Date: 20<sup>th</sup> April 2020  
Our ref: CPD: 12172020  
Your ref: 6/2020/0781/MAJ  
Direct No: 01707 355225  
E-mail: [gerry.brophy@herts.pnn.police](mailto:gerry.brophy@herts.pnn.police).

**Re: Accord House 28 Bridge Road East**

Thank you for sight of this additional housing application at this site, on which I comment from a crime prevention and safety aspect only.

Drawing
 Proposed Floor Plans
 Ground - Third Floor

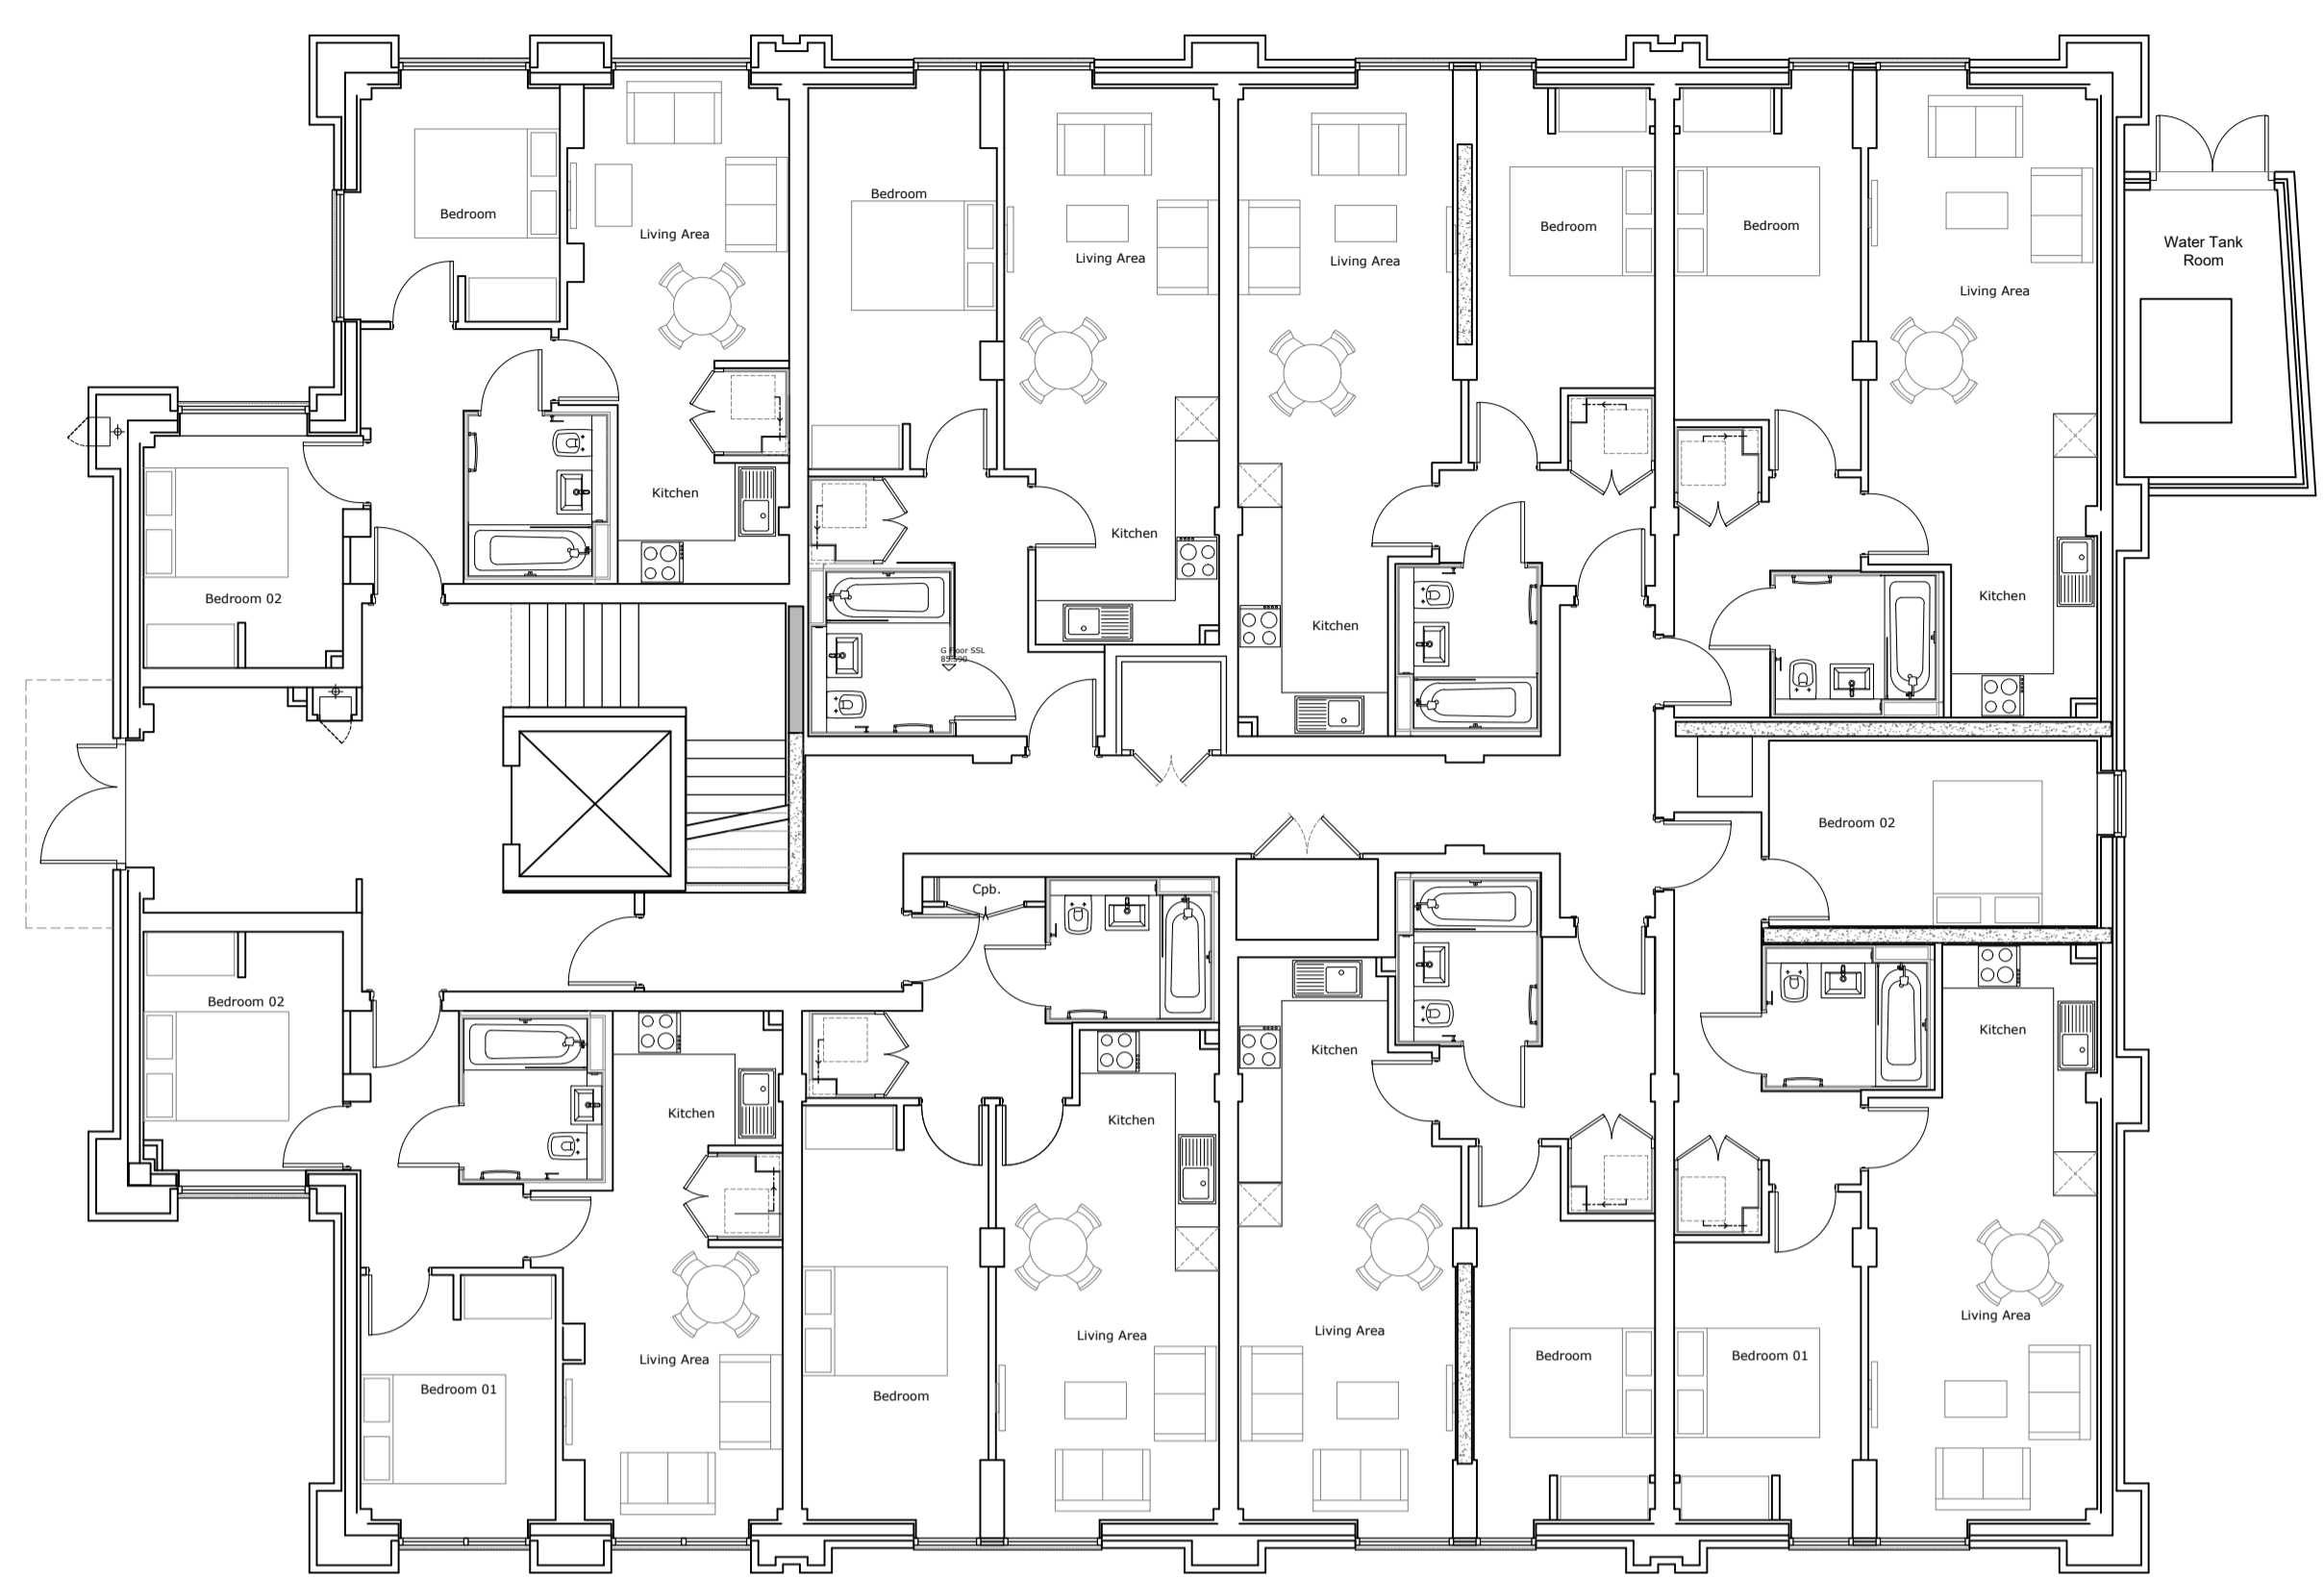
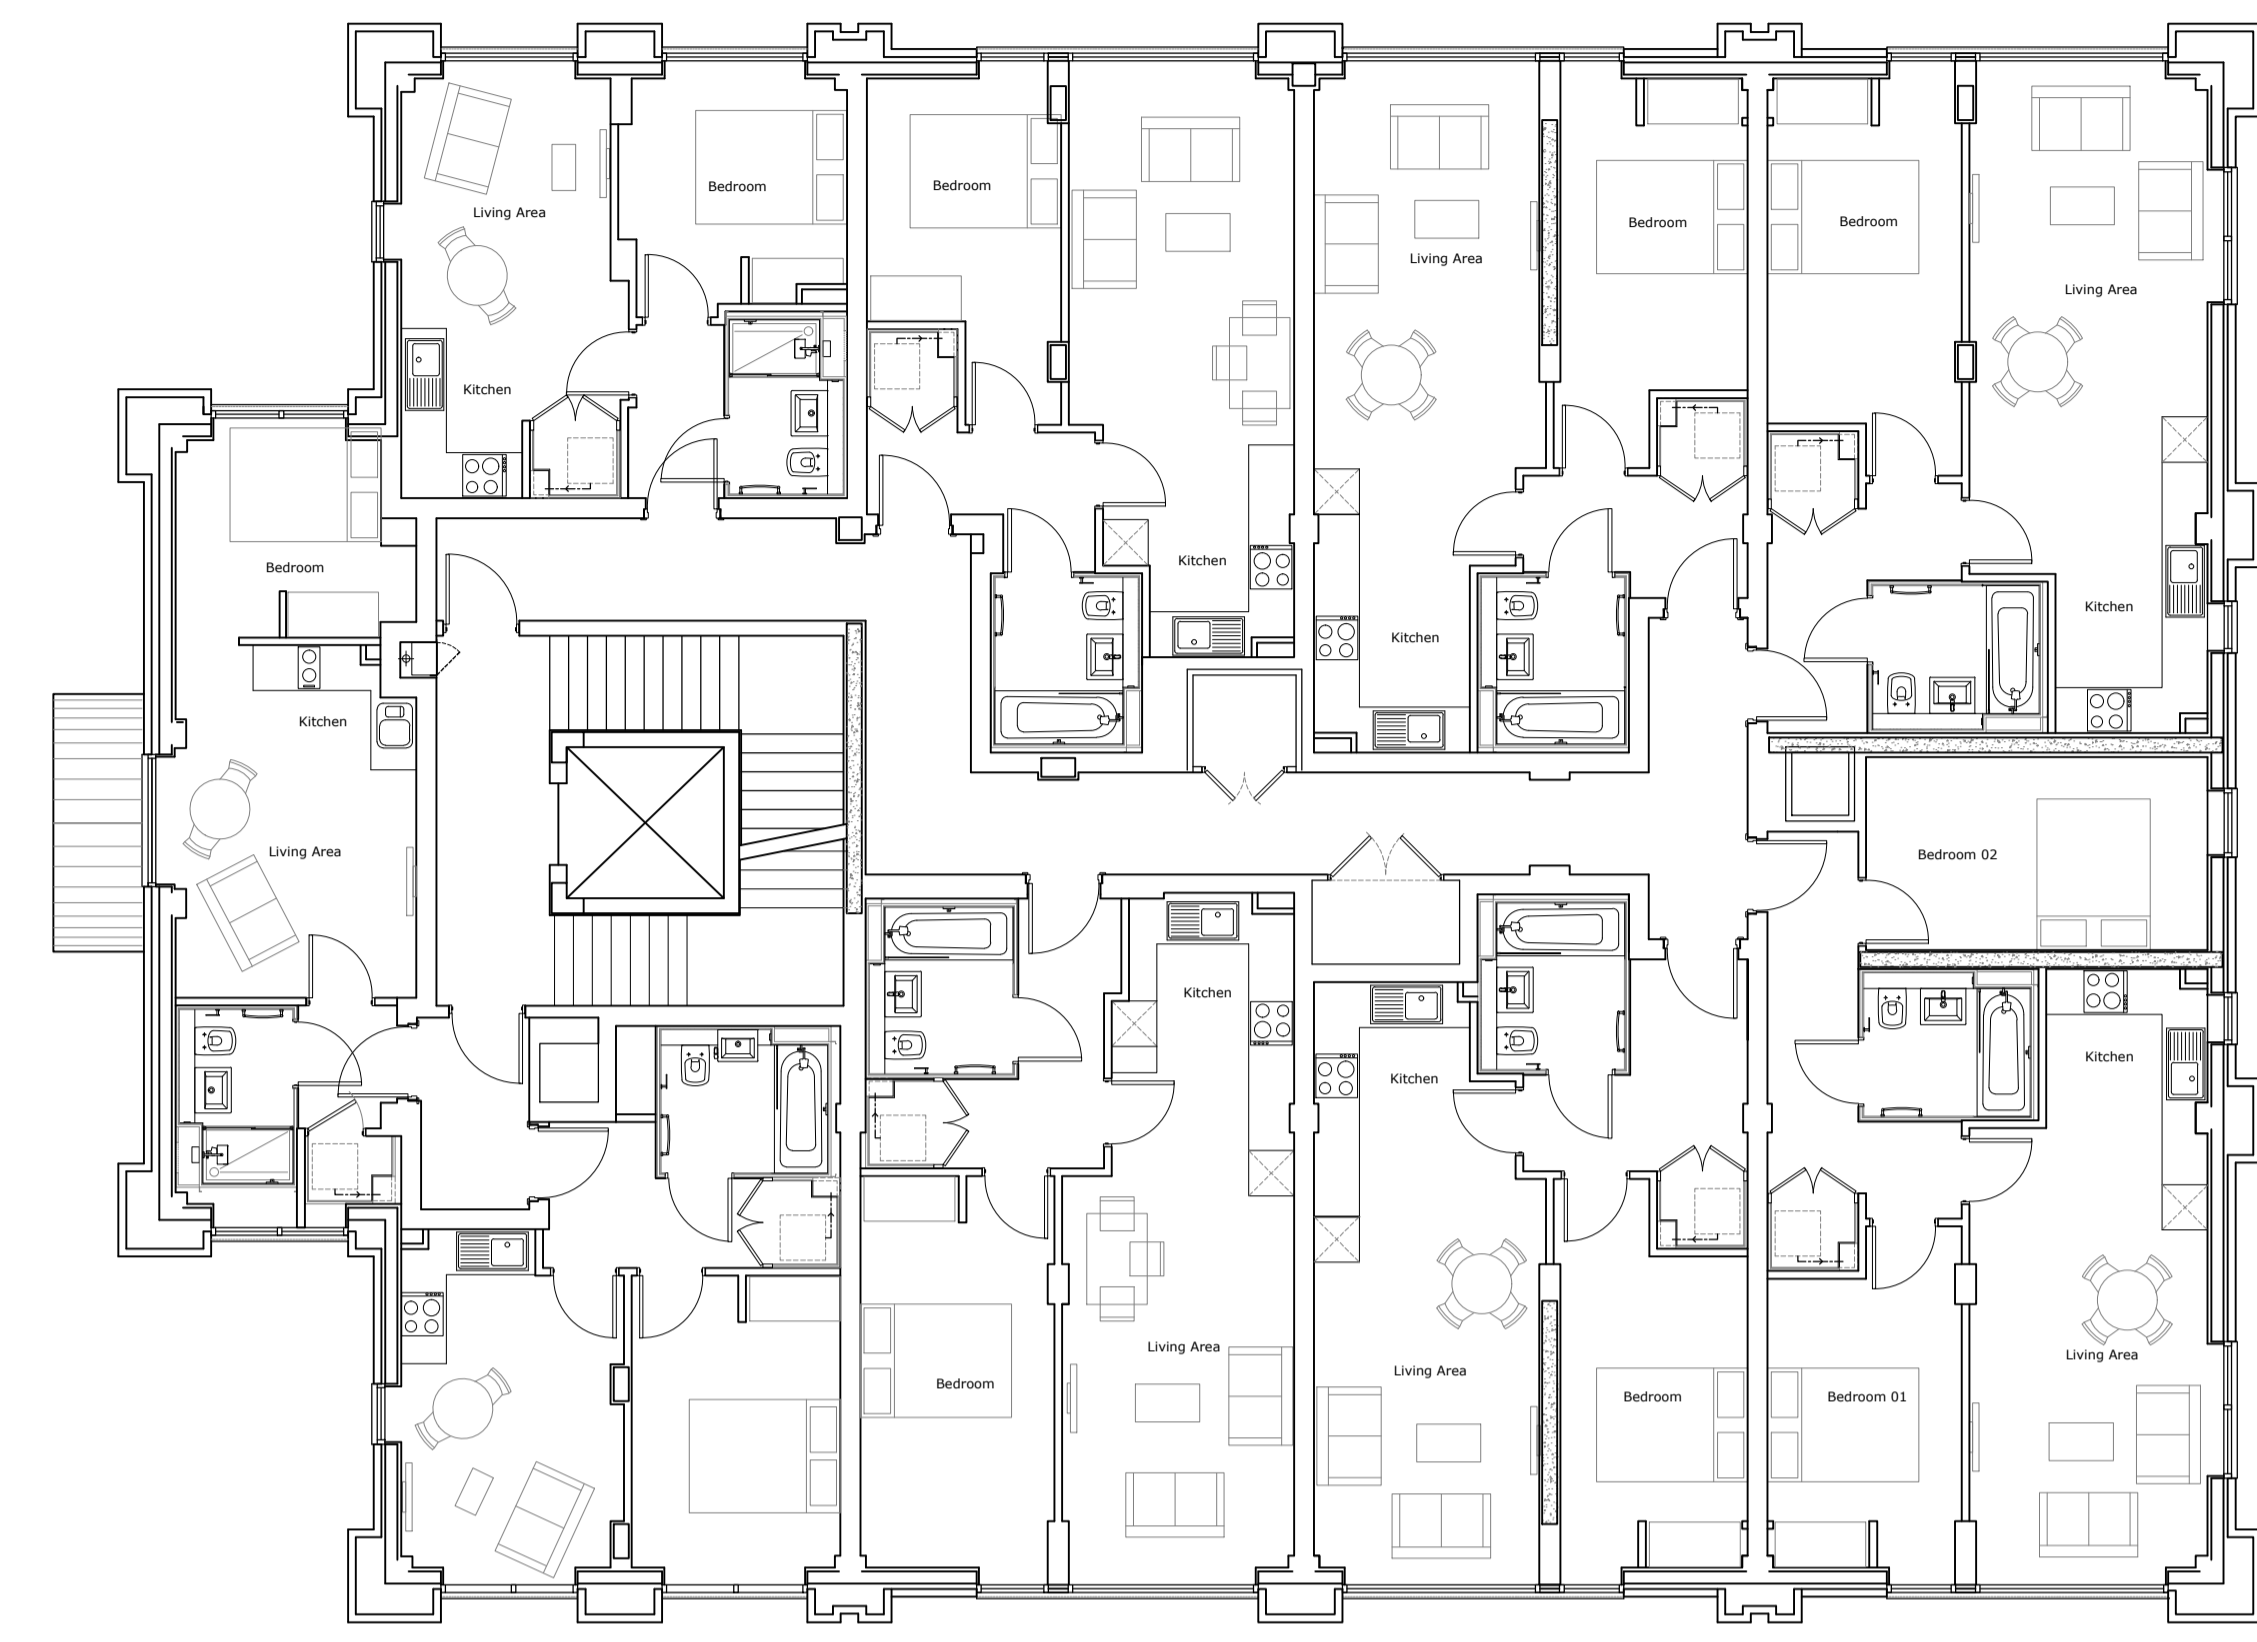
I am concerned with the intention to remove the second stairwell. In the event of a fire in or near the ground floor stairwell, there is no other safe escape route for residents above ground level. I would like to see a second means of escape from this medium height building.

Audio visual access control must be fitted to the main entrance door. Either the lift must have access control to each floor or the door leading to an average of seven (7) flats on each floor must have a fob type access control system in place.

The large wall that abuts Mercury House will have no windows to prevent overlooking. This also prevents natural surveillance and can allow criminal activity to flourish in the resultant narrow triangular piece of land that serves little purpose or use and will need to be enclosed to prevent abuse.
